Planning Application Comments

**Planning Application Number:** 21/00922/OUT

**Drawing Number(s):** LO1 and Planning, Design & Access Statement

**Site Name:** Land west of Foxden Way, Great Bourton, OX17 1QY

### Location Plan

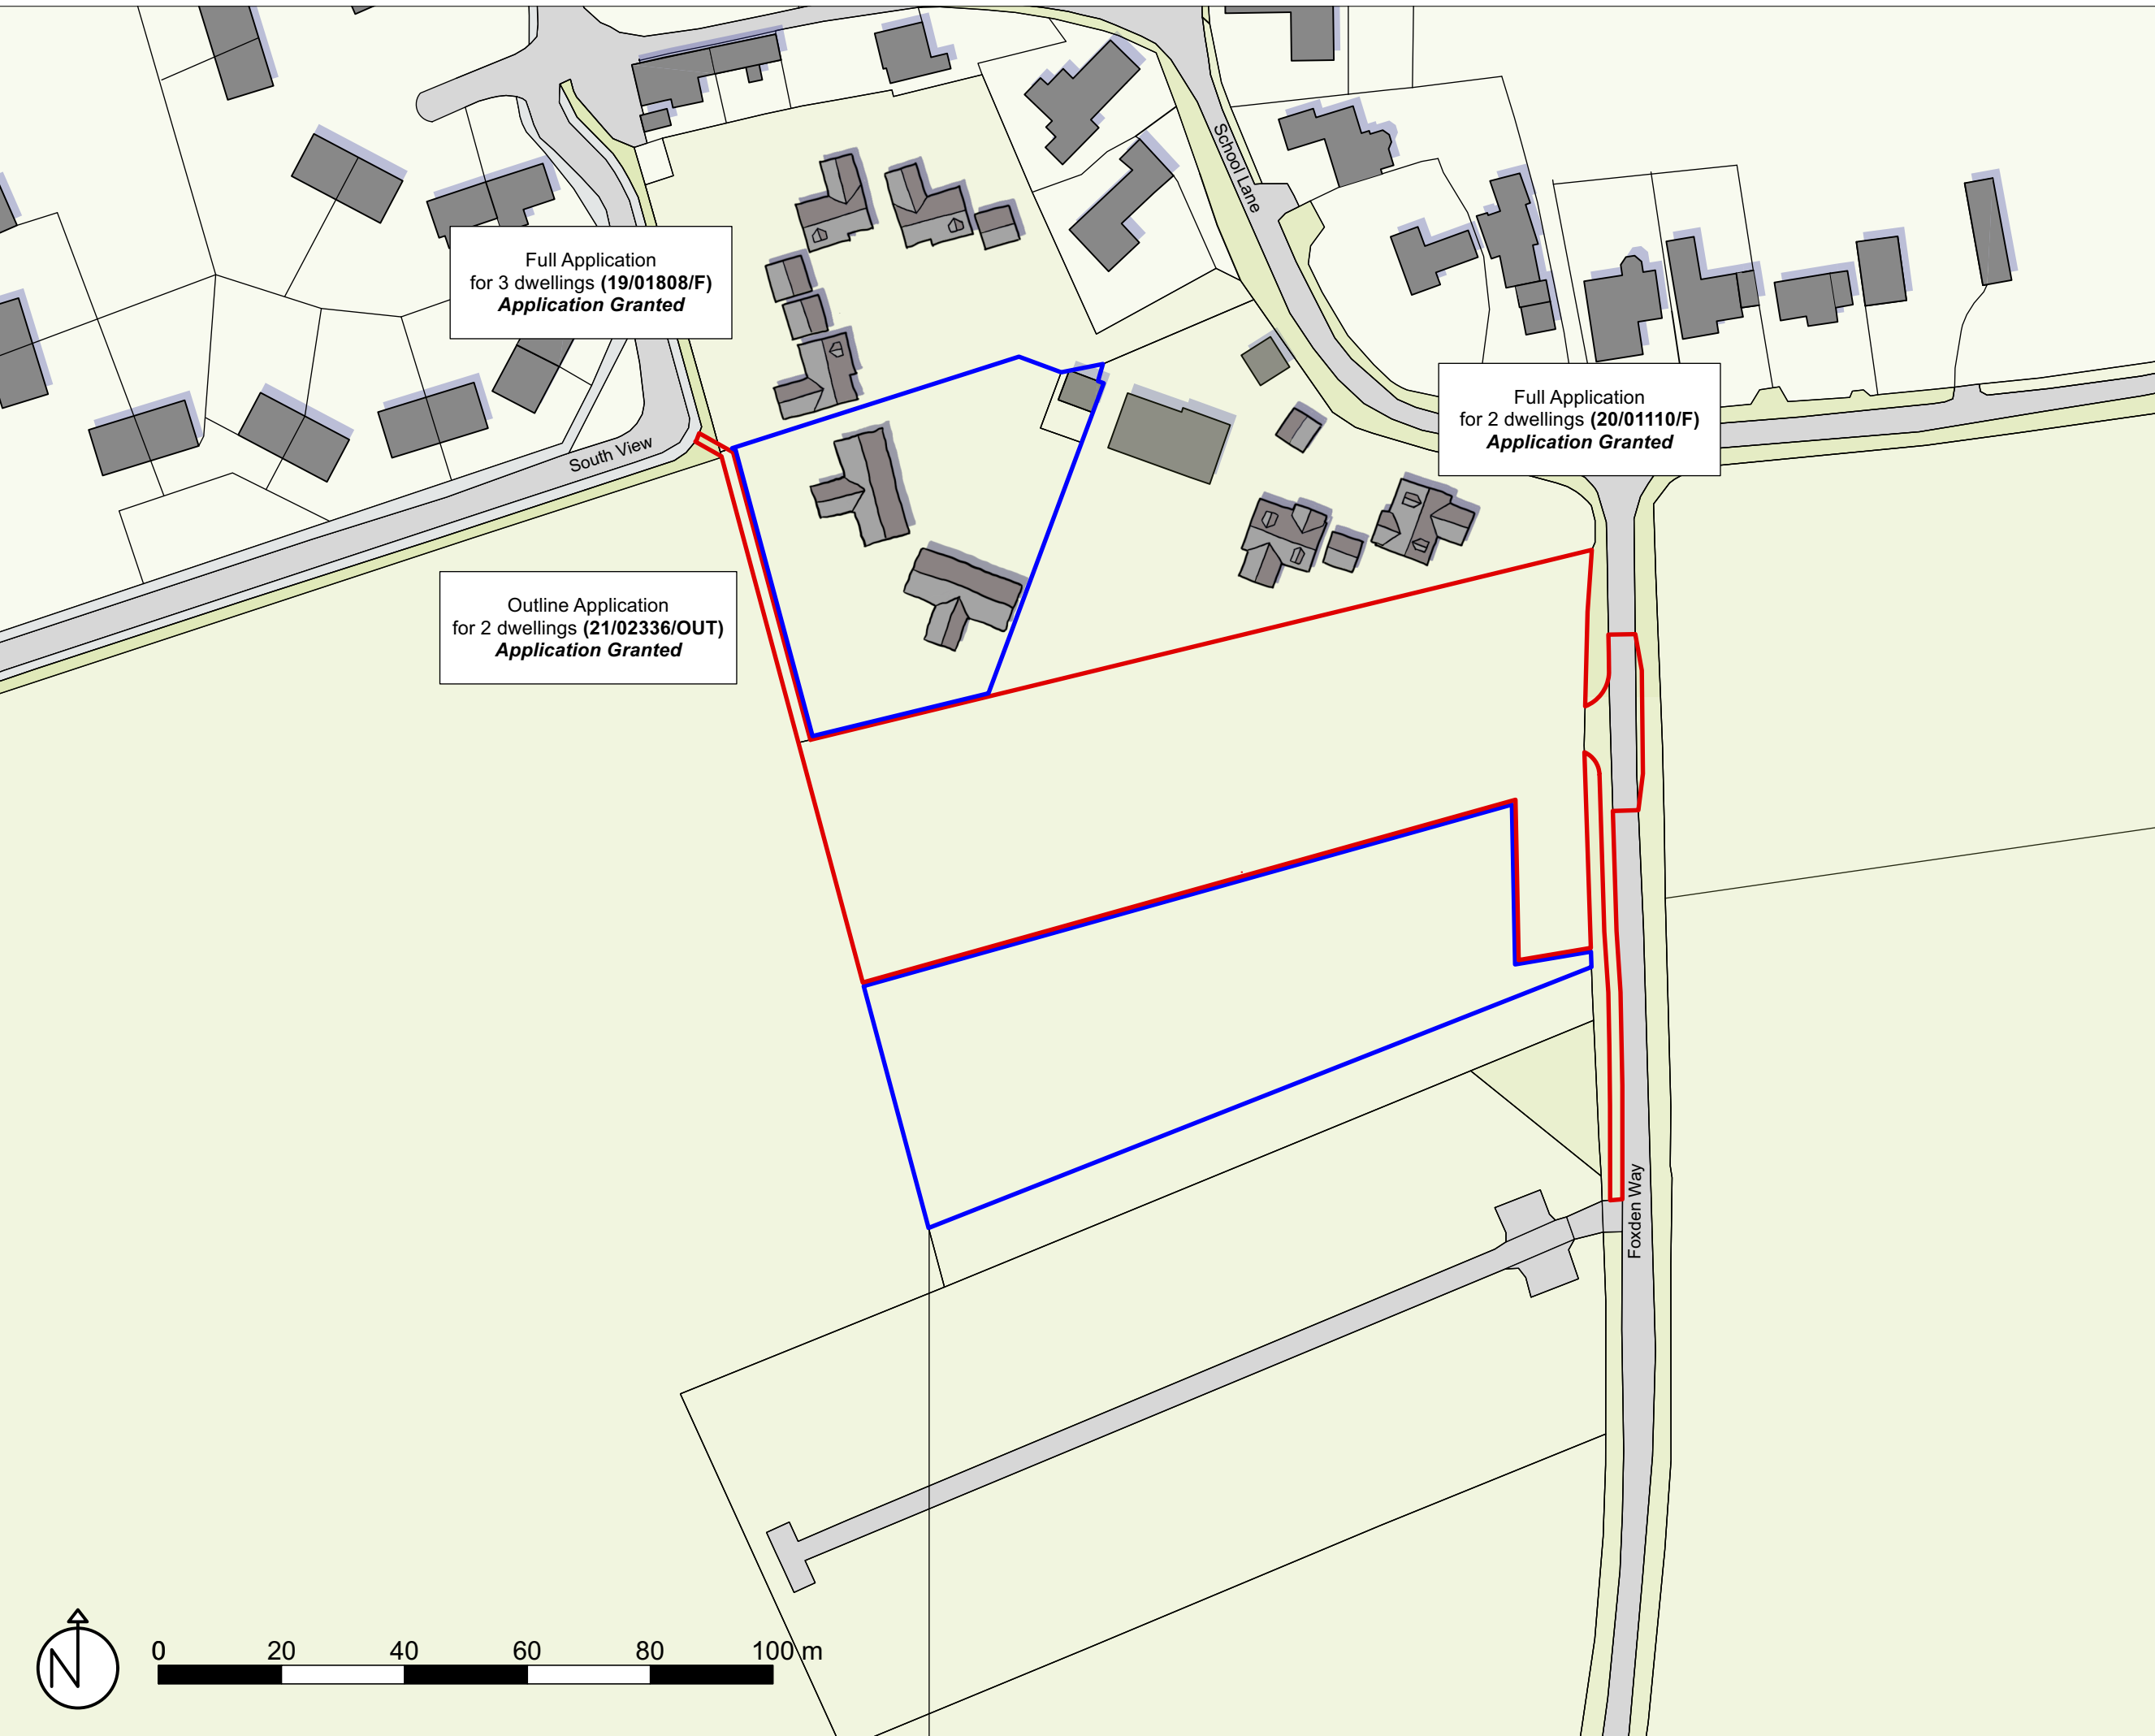
Whilst the indicative site layout plan shown in appendix 2 of the PDAS, shows 2 no. bungalows, the parking for these units does not appear to relate well to the front of these homes and if they were to be wheelchair accessible or adaptable dwellings, then the parking needs to be located to the front, with ease of access to the main entrance. The current indicative layout would not be acceptable.
